From: Philip William [REDACTED]
Sent: 26 July 2021 20:15
To: Planning <Planning@arun.gov.uk>
Subject: Planning Application EP/69/21/PL

I am writing to object to the planning application EP/69/21/PL for a 3 bedroom bungalow to be built east of 18 Beechlands Court. I live locally and have regularly visited a close relative that resides in one of the flats in Beechlands Court, for many years. So I feel that I know the road and residents very well.

Client	Description
c/o RSP ARCHITECTS LTD	PROPOSED PLANS, ELEVATIONS & SECTION

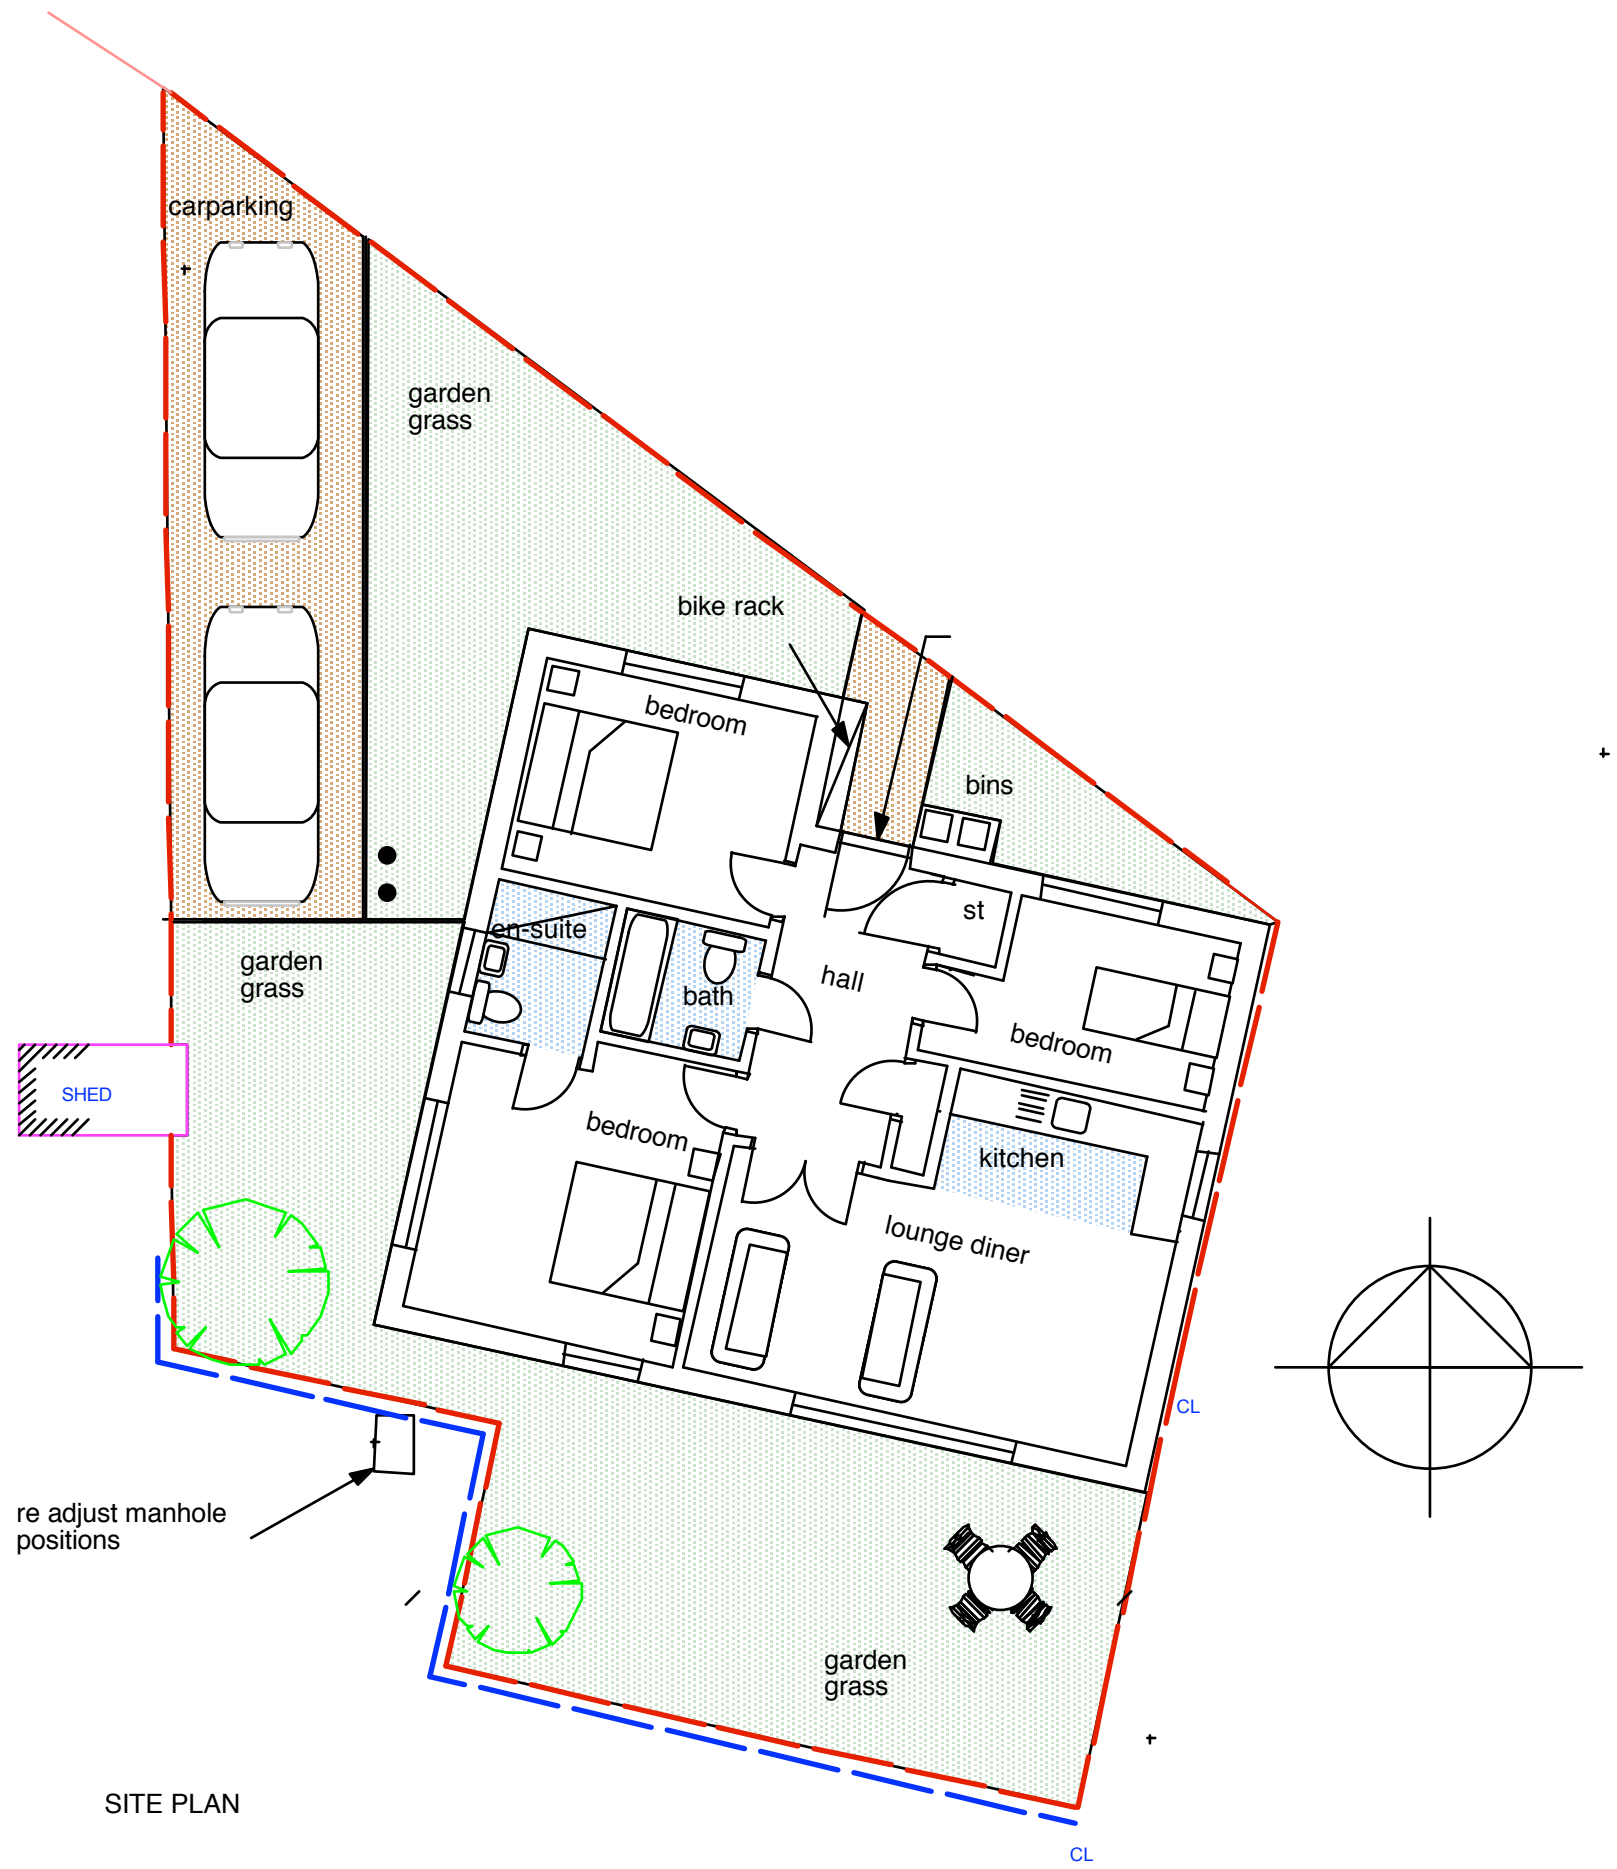
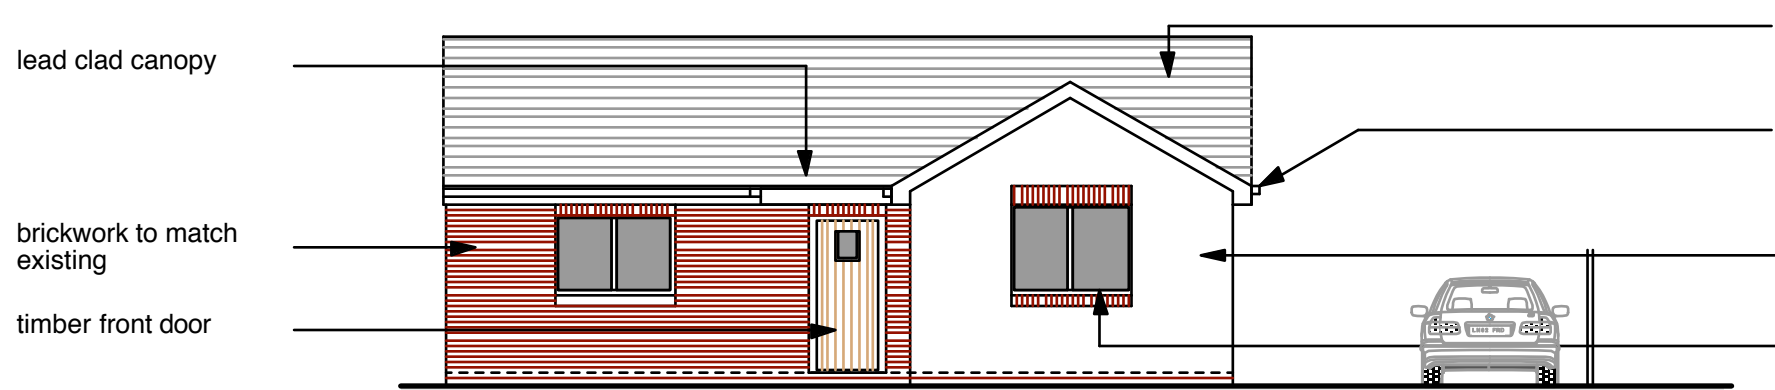
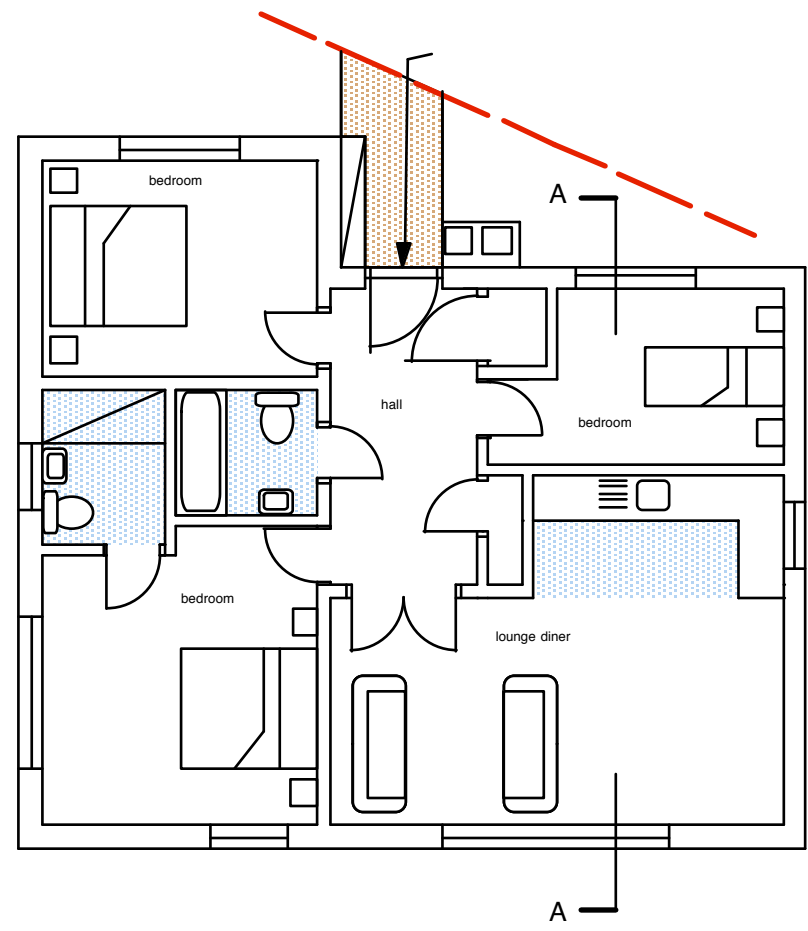
The area is very built up and this parcel of land provides a much needed open space for the residents. I fear that if a property is built on this land, then Beechlands Court will feel very cramped and over developed. The road between the potential bungalow and the opposite flats is also very narrow, so I feel that the ground floor flats opposite will be overlooked and will lose valuable sunlight.

There currently arent enough parking spaces for the residents of Beechlands Court and in the evenings and weekends, it is very hard to find any parking spaces at all. Looking at the plans for the bungalow, it seems that the

current off road parking for 18 Beechlands Court will be taken away. This, combined with potential guests visiting the residents of the bungalow from time to time will cause further competition for parking spaces. There are some elderly residents that live in Beechlands Court and it will be very difficult for them to walk any kind of distance, to their property, especially with shopping etc.
